**Consultation Response from KC,
Lead Local Flood Authority**

2024/92651 land at, Blackmoorfoot Road, Crosland Hill, Huddersfield, HD4 5NU

Hybrid planning application comprising full application for erection of industrial units (use classes E(g)(ii-iii), B2, and B8) in Units 1 and 2, including ancillary offices, mezzanines, landscaping, parking and formation of new access, and outline application with all matters reserved for erection of industrial units (use classes E(g)(ii-iii), B2, and B8).

Date Responded: 1st November 2024

TITLE
EXISTING
IMPERMEABLE AREAS

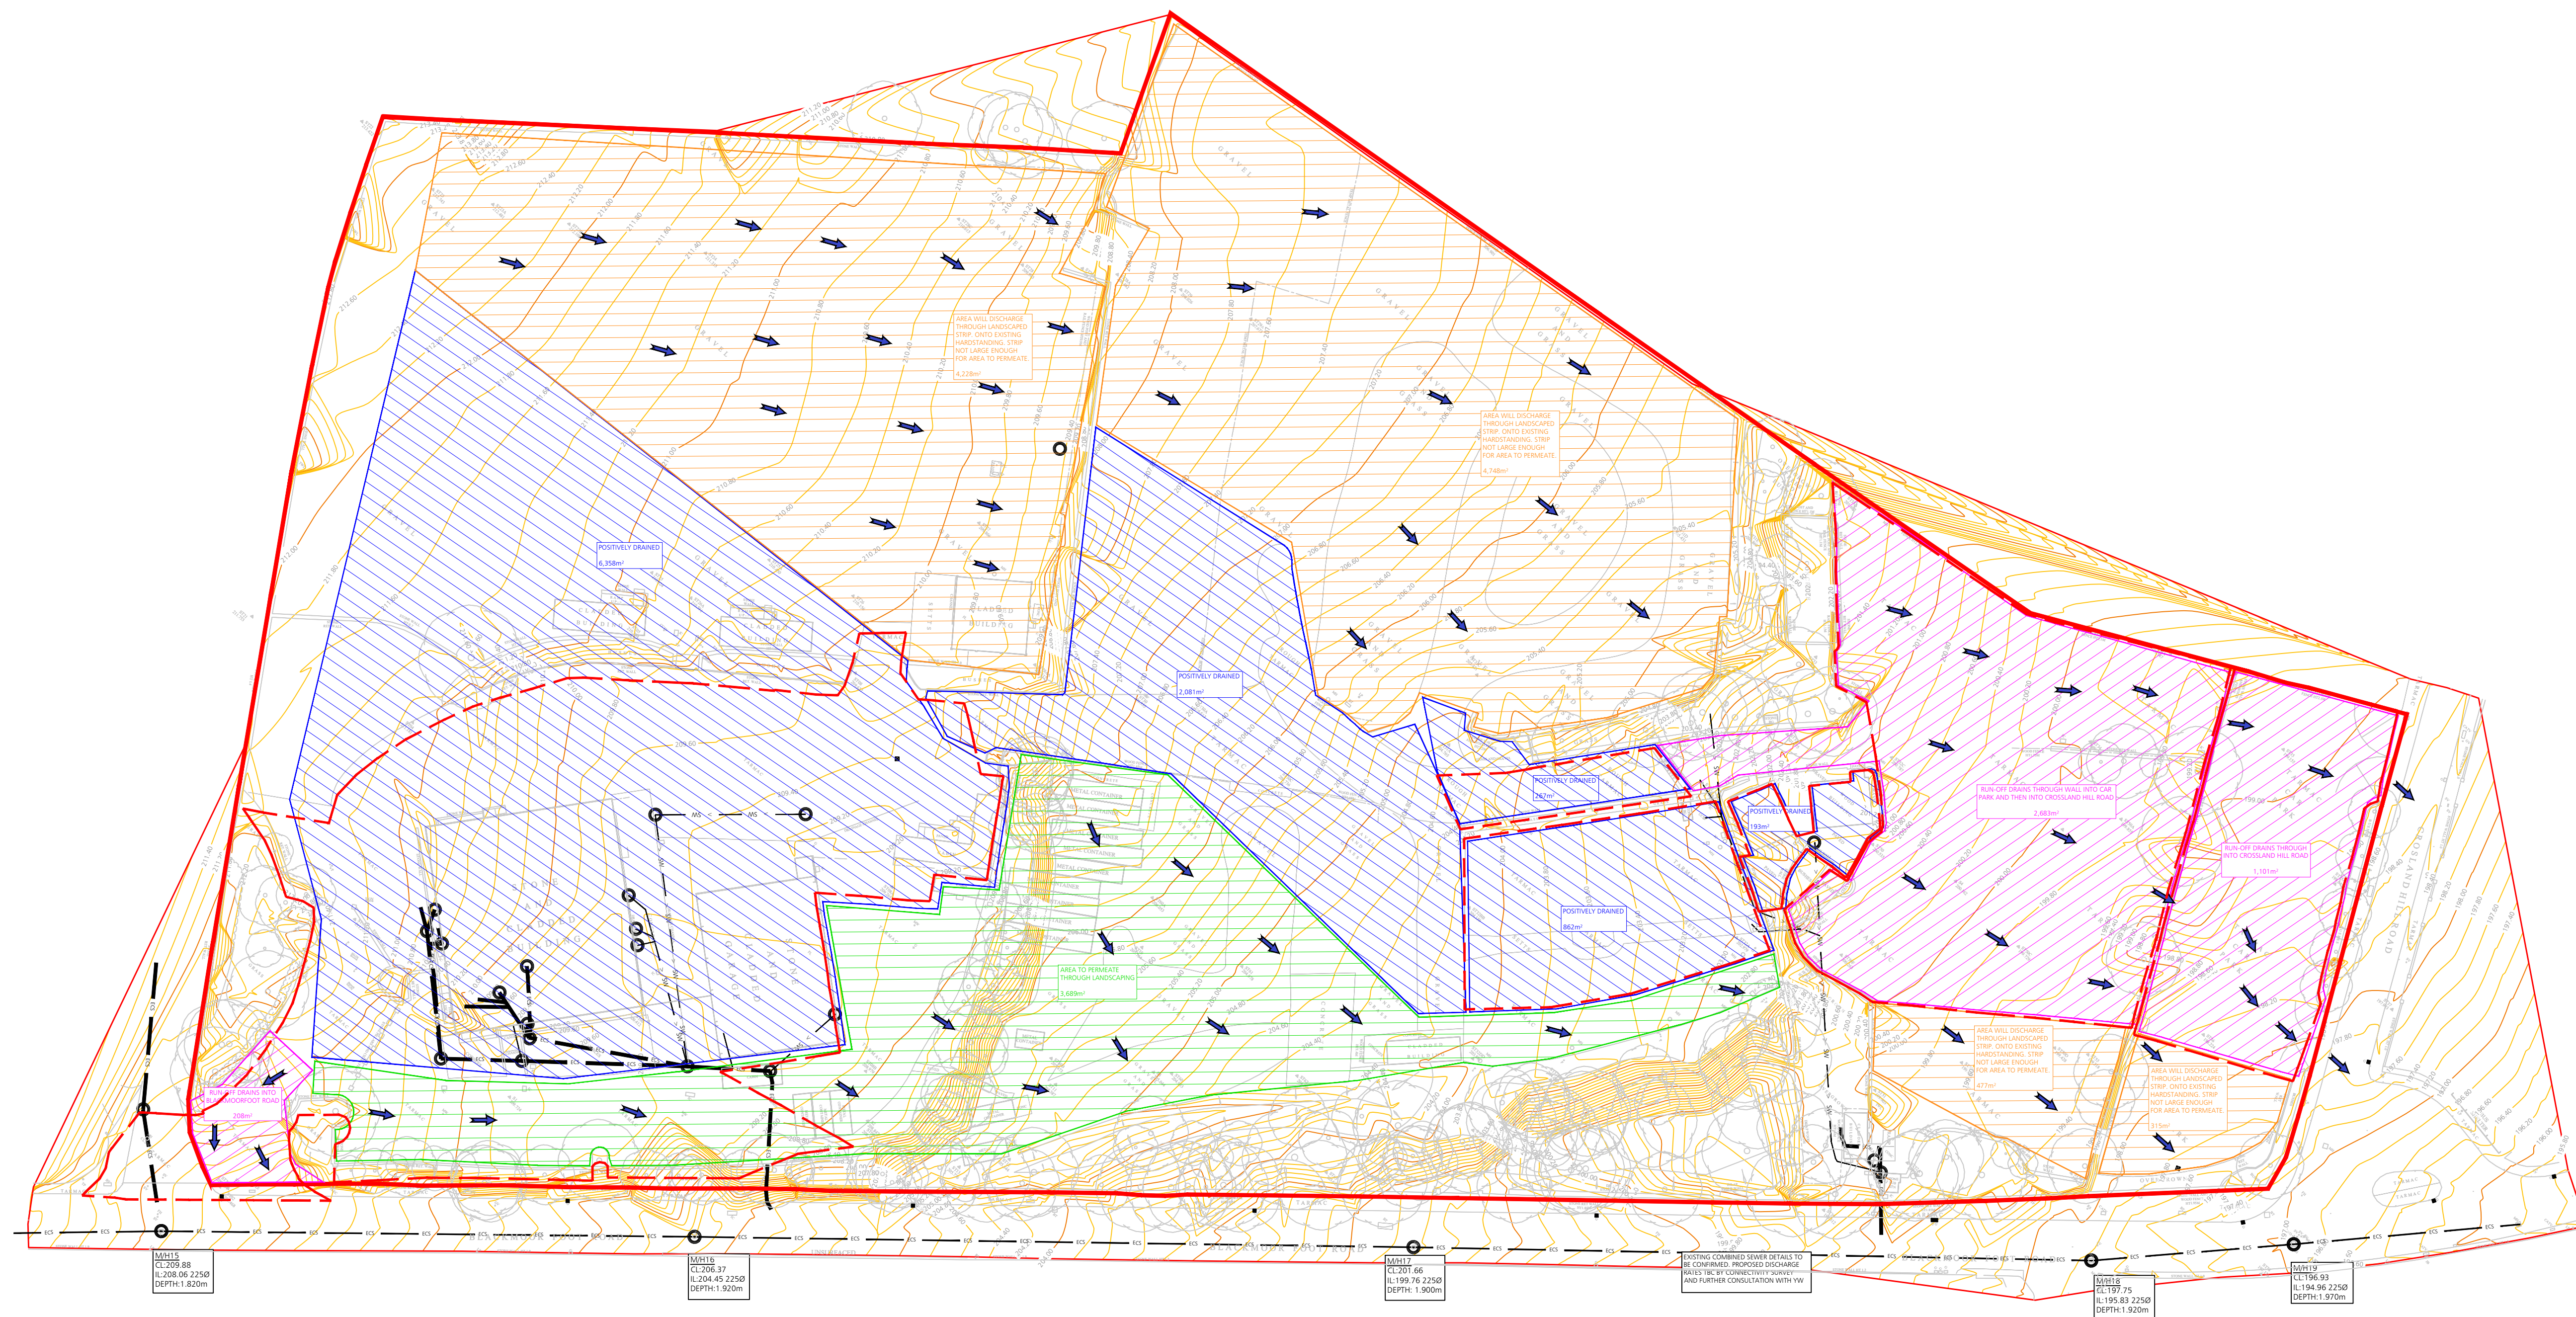
There are discrepancies between research and conclusions on existing positively drained areas on this site between this application and a previous application under 2021/93150.

Both sites show areas of hard standing that drain to landscaped areas and have been discounted. However, it appears that areas of hardstanding that drain off site have been included in this application and omitted in the previous application. The LLFA's stance usually discounts areas not positively drainage within the site.

The previous application promoted a discharge restriction of 47.7l/s. This application promotes a discharge restriction double this at 95l/s.

Kirklees LLFA therefore OBJECTS to the justification for 95l/s on this site. However, should Yorkshire Water not object to this discharge rate, Kirklees LLFA are willing to re-consider since the discharge will be to a public combined sewer.
